CITY OF ALBUQUERQUE

**Re: Cheddars Casual Cafe, 4865 Pan American Frwy NE,
Request for Permanent C.O. –Accepted
Engineer's Stamp dated: 4-9-13, (F17/D006)
Certification dated: 10-23-13**

Based upon the information provided in the Certification received 10-24-13, the above referenced Certification is acceptable for a release of a Permanent Certificate of Occupancy by Hydrology.

TEMPORARY SWALE DETAIL SECTION A-A

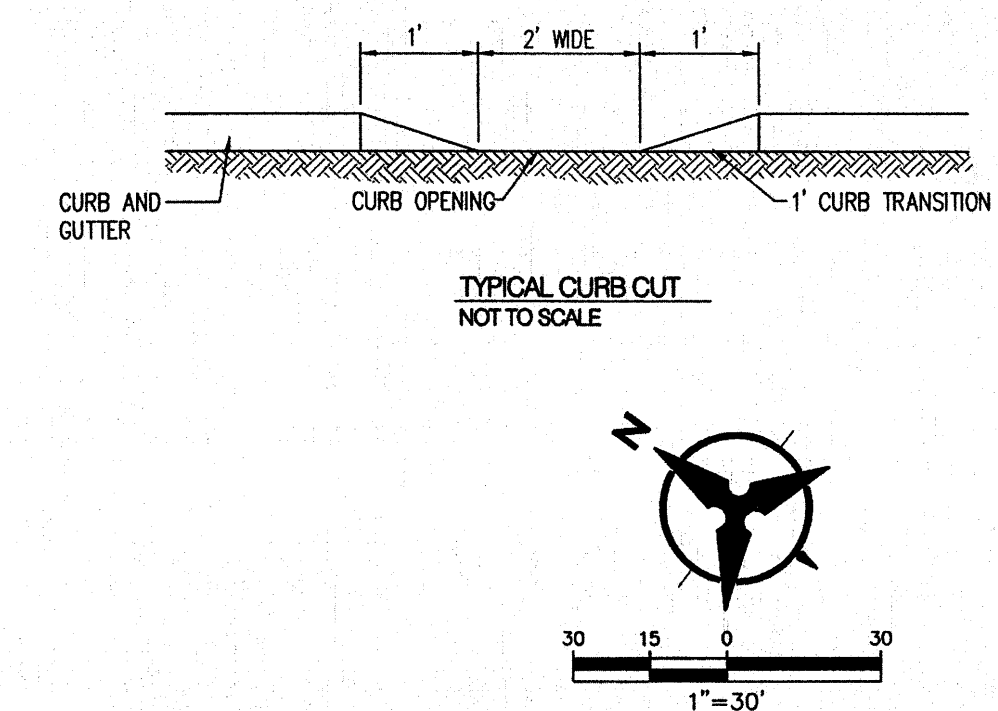
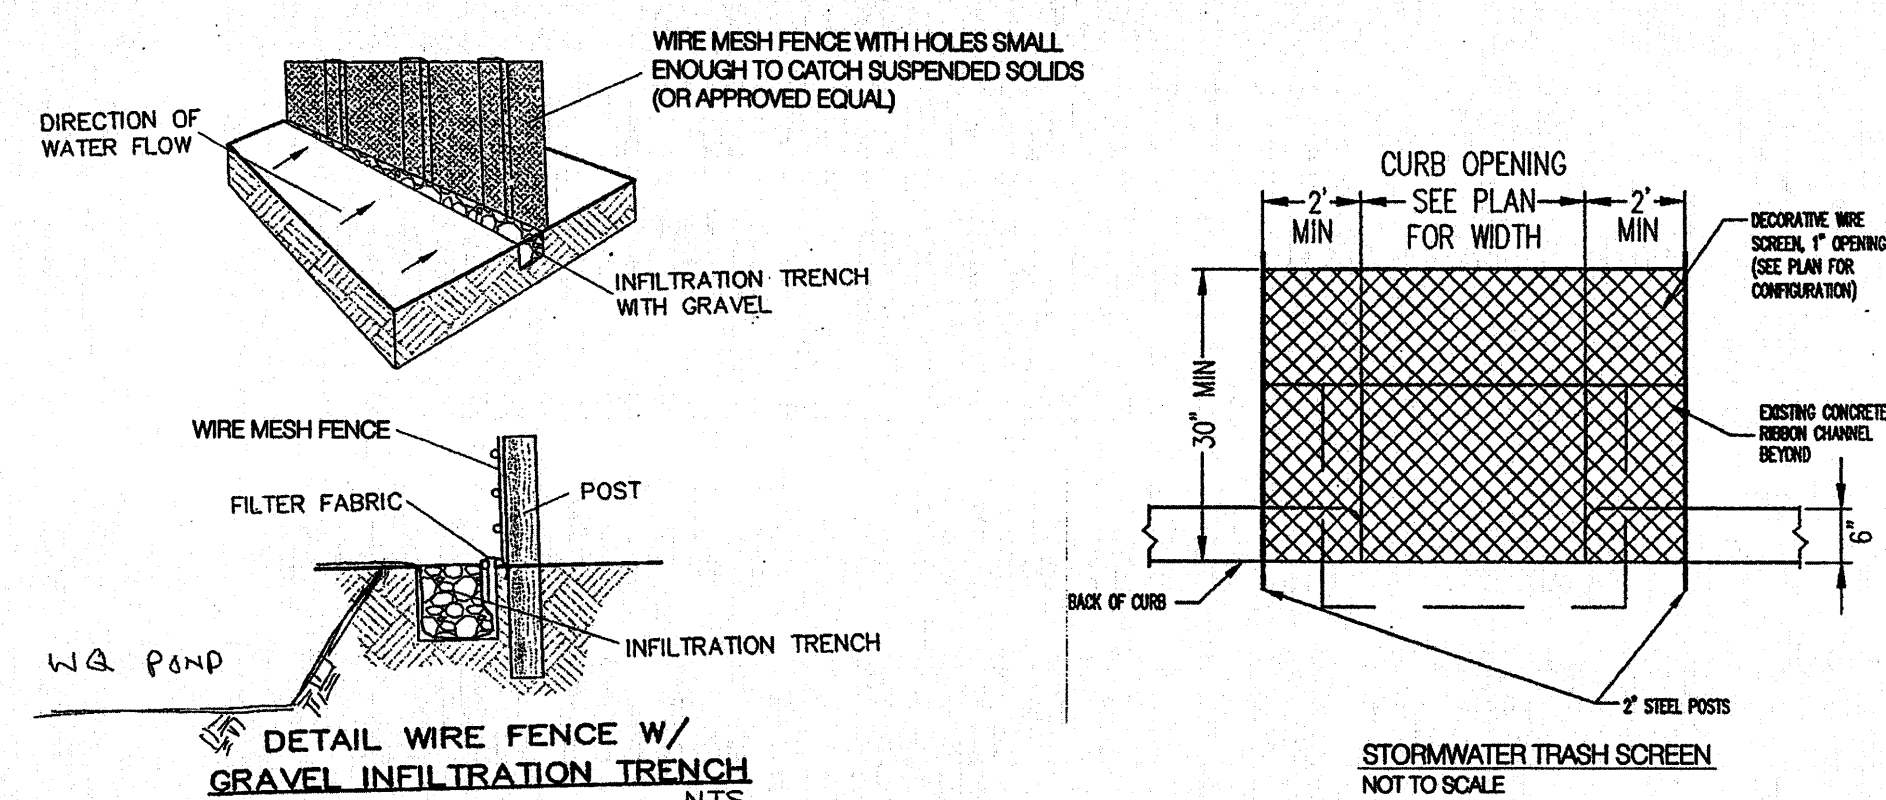
During a site visit, Hydrology noticed that the curb cut at the west end of the parking lot was only 16" wide not the 24" wide as certified on your plan. In addition, a 10' piece of temporary curbing had been knocked out along the southern edge of the east-west drive aisle. The result of these modifications to the drainage plan are that the "clean" site water will deposit sediment in the inlet at the site outfall. This was acceptable to AMAFCA.

With future certifications, the above mentioned deviations should be listed in the exceptions area of the certification language.
